18th February 2021

Re: Request for Advice – Sirius Developmentm 2-60 Cumberland Street, The Rocks (Landscape)
Council Ref: R/2019/20/A
File No: 2020/564775
Ref: SSD-10384

Further to the requested conditions outlined in PMNSW Response to Environmental Impact Statement – SSD 10384, we provide the following response in relation to landscape specific items.

L-DA-018

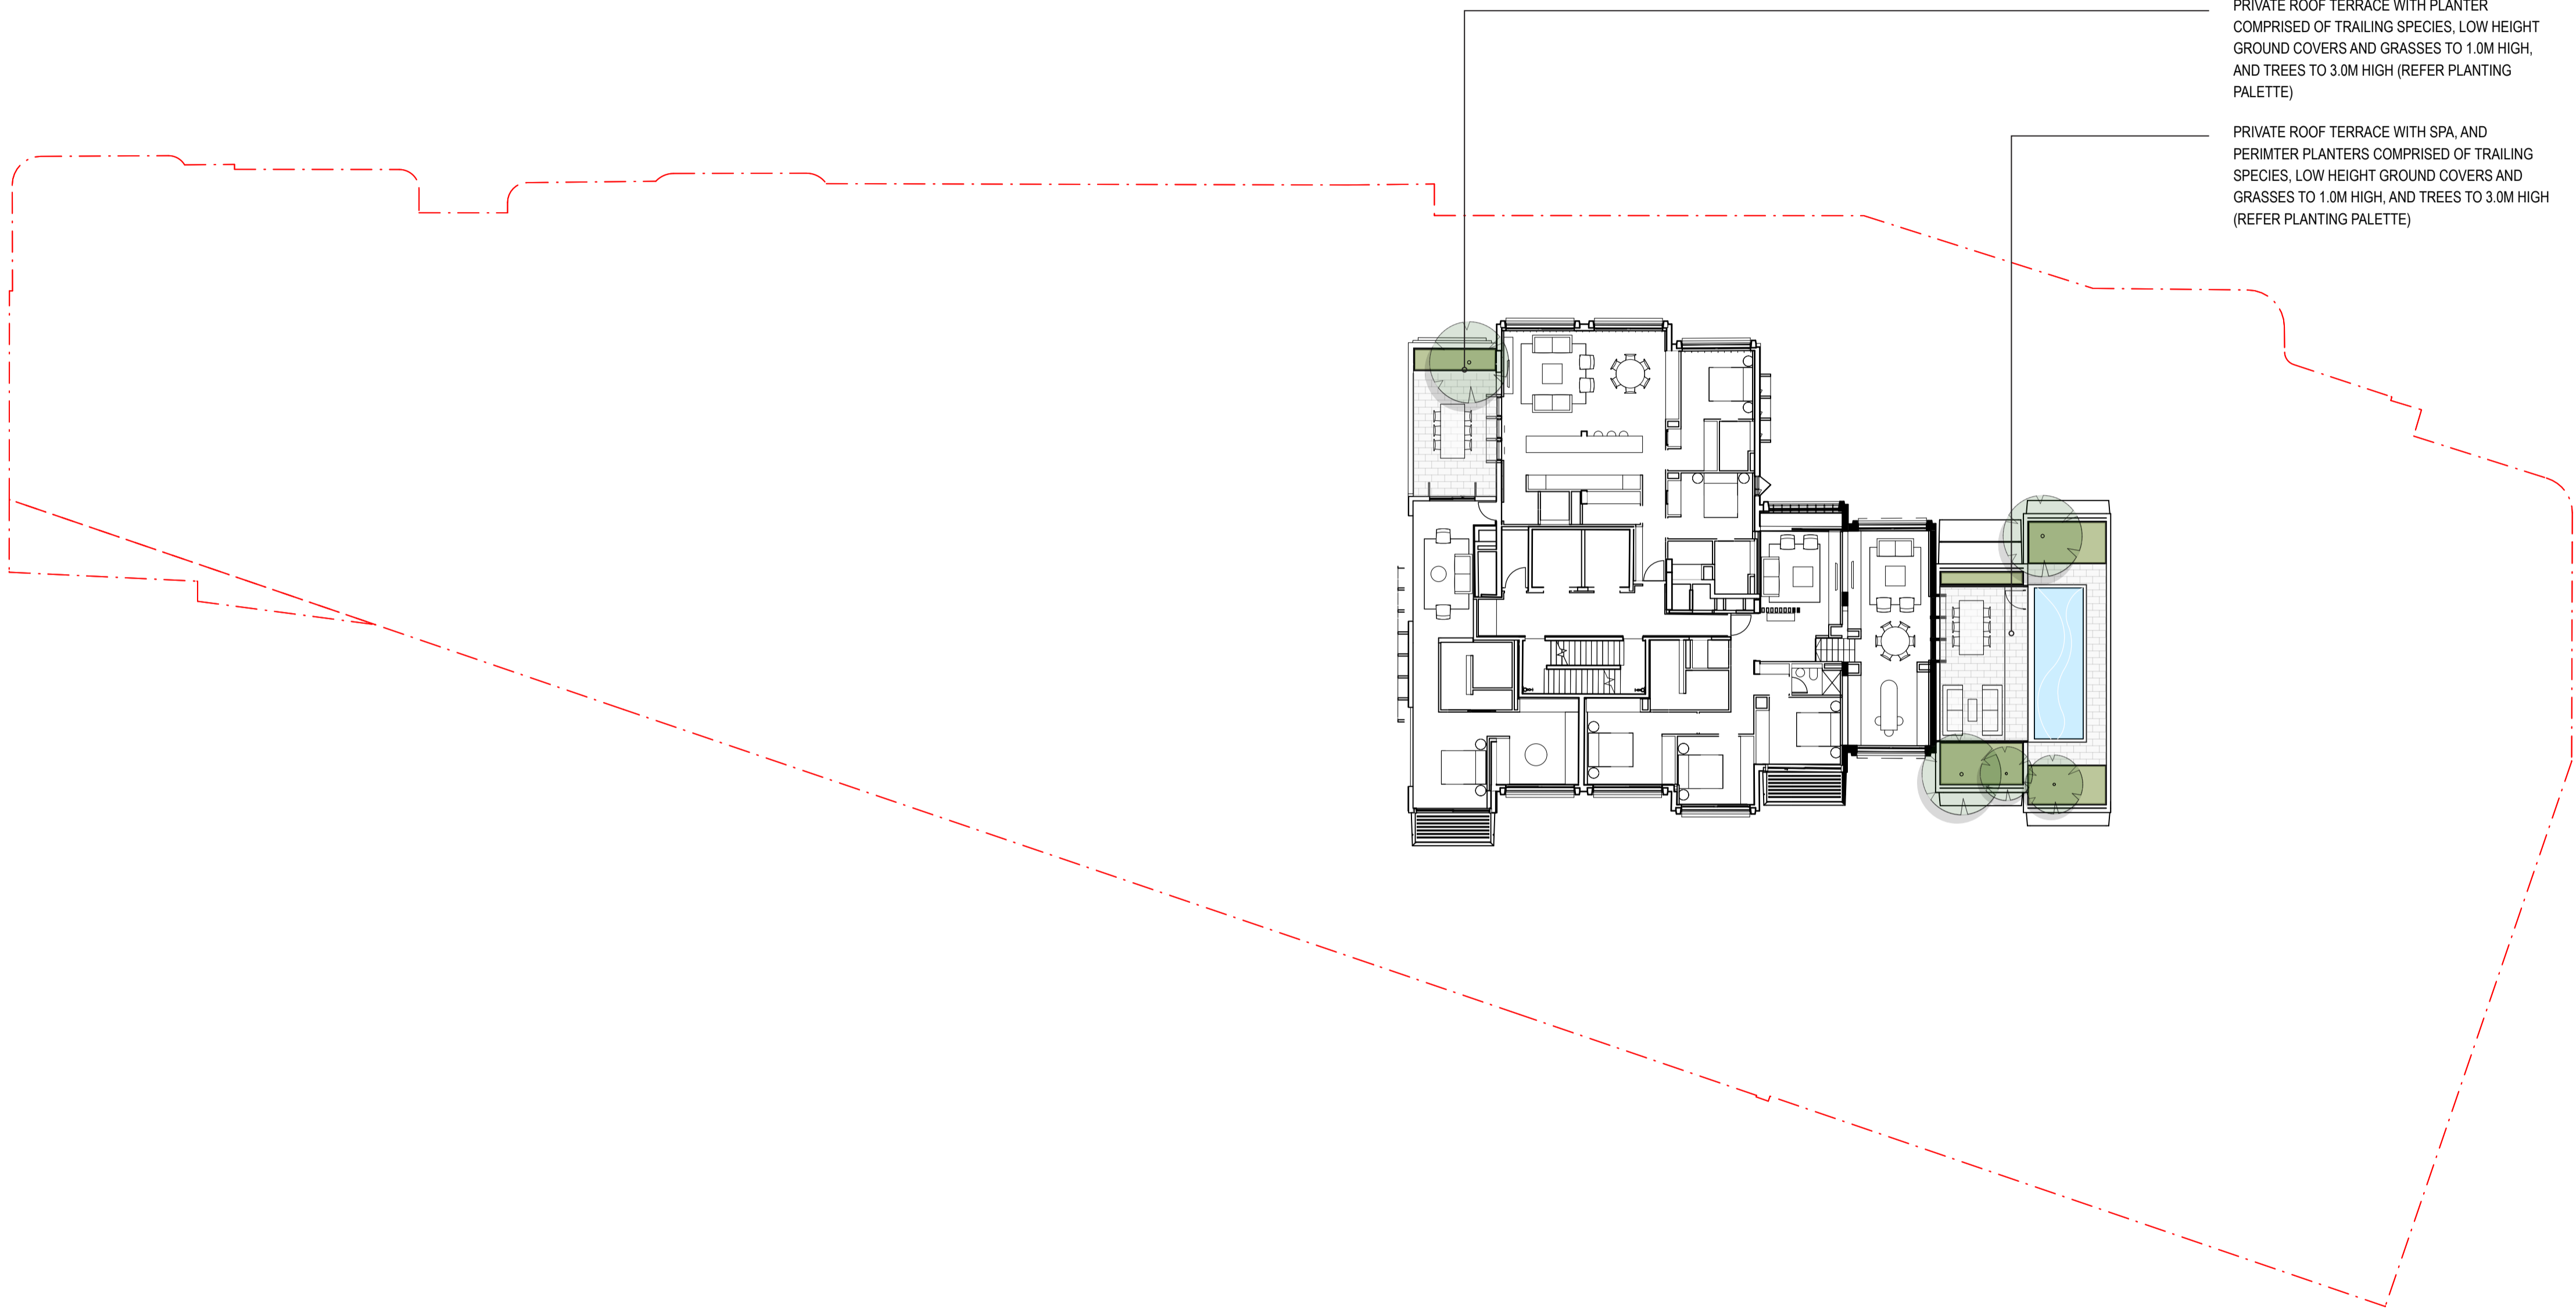
Design Review Panel Comments - Green Roof Maintenance

Comments raised in the Design Panel comments 3.15 (1st Review) and 3.8 (2nd Review) regarding maintenance of the Green Roofs, access and methodology have been addressed (*Refer Appendix D – Rooftop Access and Maintenance*).

The green roofs are maintained via a series of permanent ladders and static lines that are accessed from manholes located within the central cores. All private rooftop gardens are accessed for maintenance from within the terrace via static line connection.

A detailed Green Roof maintenance Access and Methodology report will be prepared and submitted to City of Sydney for approval prior to the issue of final LOC or CC.
